Development Control
Ribble Valley Borough Council

App no: 23.0160

Address: Parcel 4 Land to the west of Malt Kiln Brow Chipping

Proposal: Variation of condition 1 (plans) of reserved matters approval 3/2019/0132 to amend the proposed levels and realign the drive serving the four approved dwellings

Client	Mr S. Chicken		
Project	Parcel 4, Church Raik, Malt-Kiln Brow, Chipping		
Drawing Title	SITE LAYOUT AND LANDSCAPE CONTEXT PLAN		
Drawing No.	1624SCR/ChP4-SL1

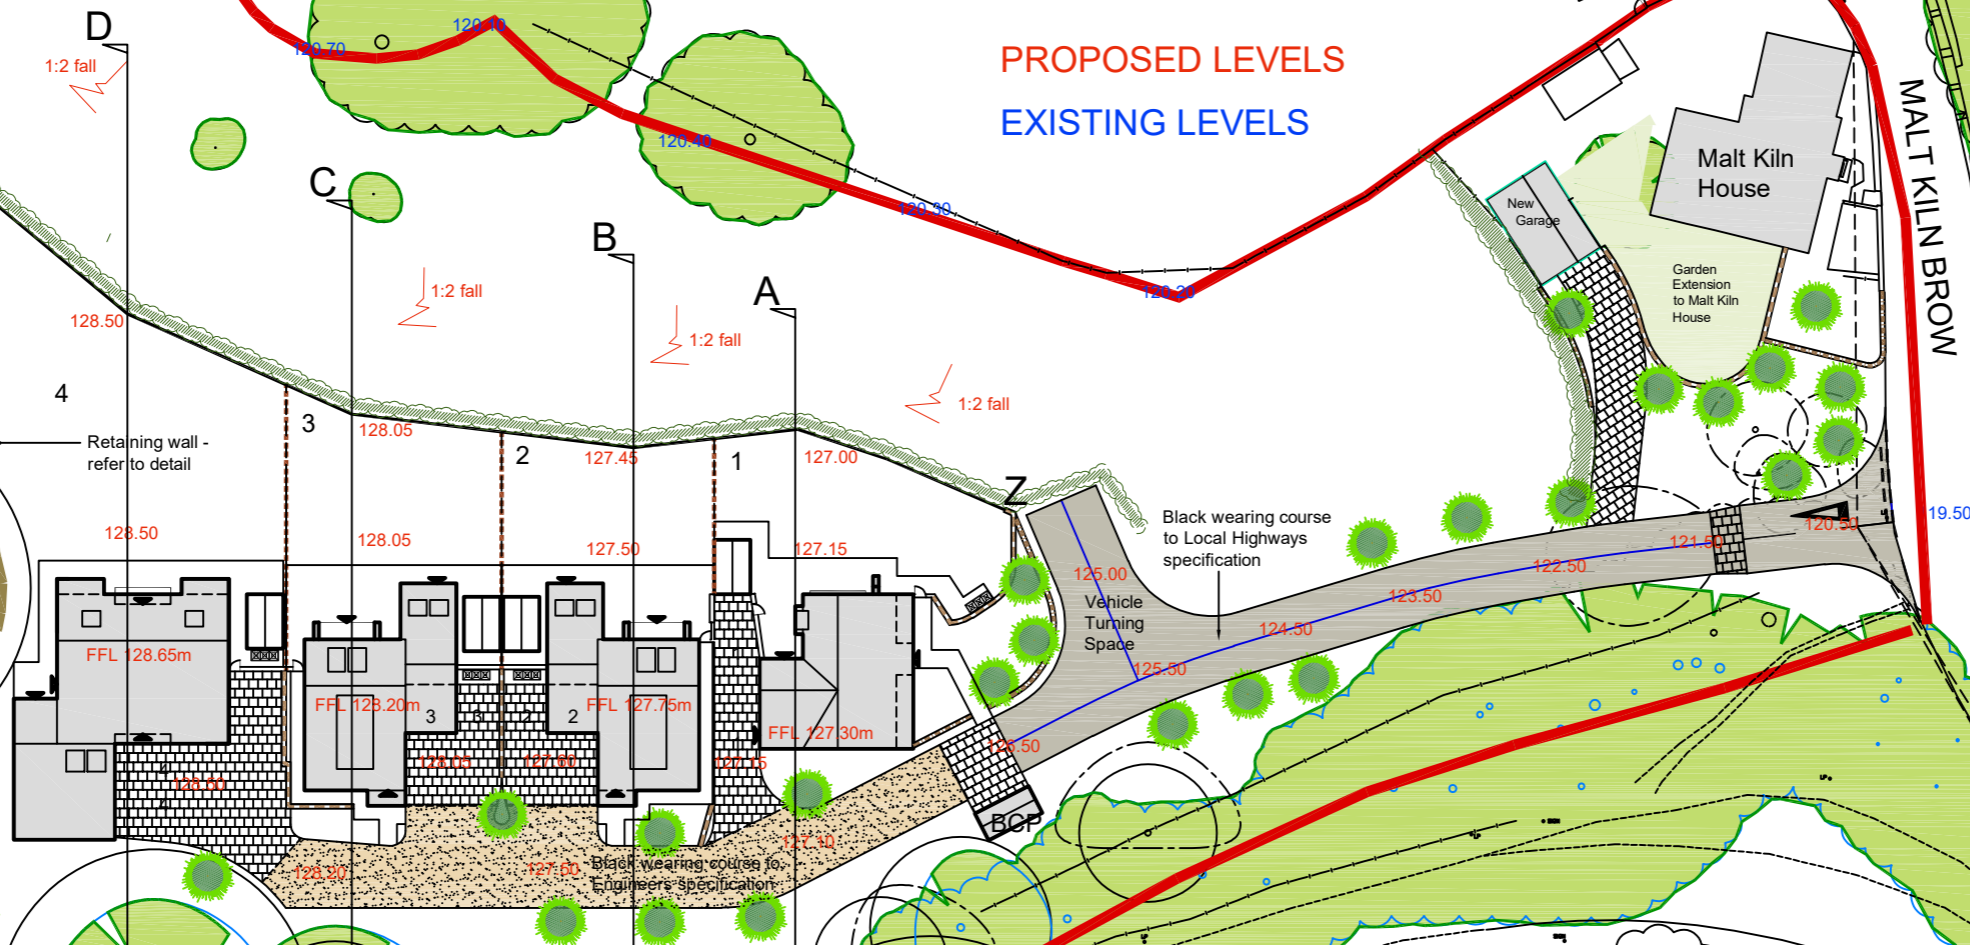
The amended plans include the removal of the footway alongside the estate road at the junction of Malt Kiln Brow. This is not supported as pedestrians will not have a safe refuge to stand whilst vehicles manoeuvre at the junction.

The amended road alignment steepens the gradient to 1:10 over the whole length and provides a very steep transition at the junction of Malt Kiln Brow. This is not supported as it is likely to provide insufficient ground clearance for large vehicles and be too steep for pedestrians with mobility issues or pedestrians pushing prams.

The previous alignment provided a maximum gradient of 1:12 with a flatter transition to the junction which was considered acceptable.

The Highway Authority would raise an objection to the variation of plans as this would not provide a safe and suitable access.
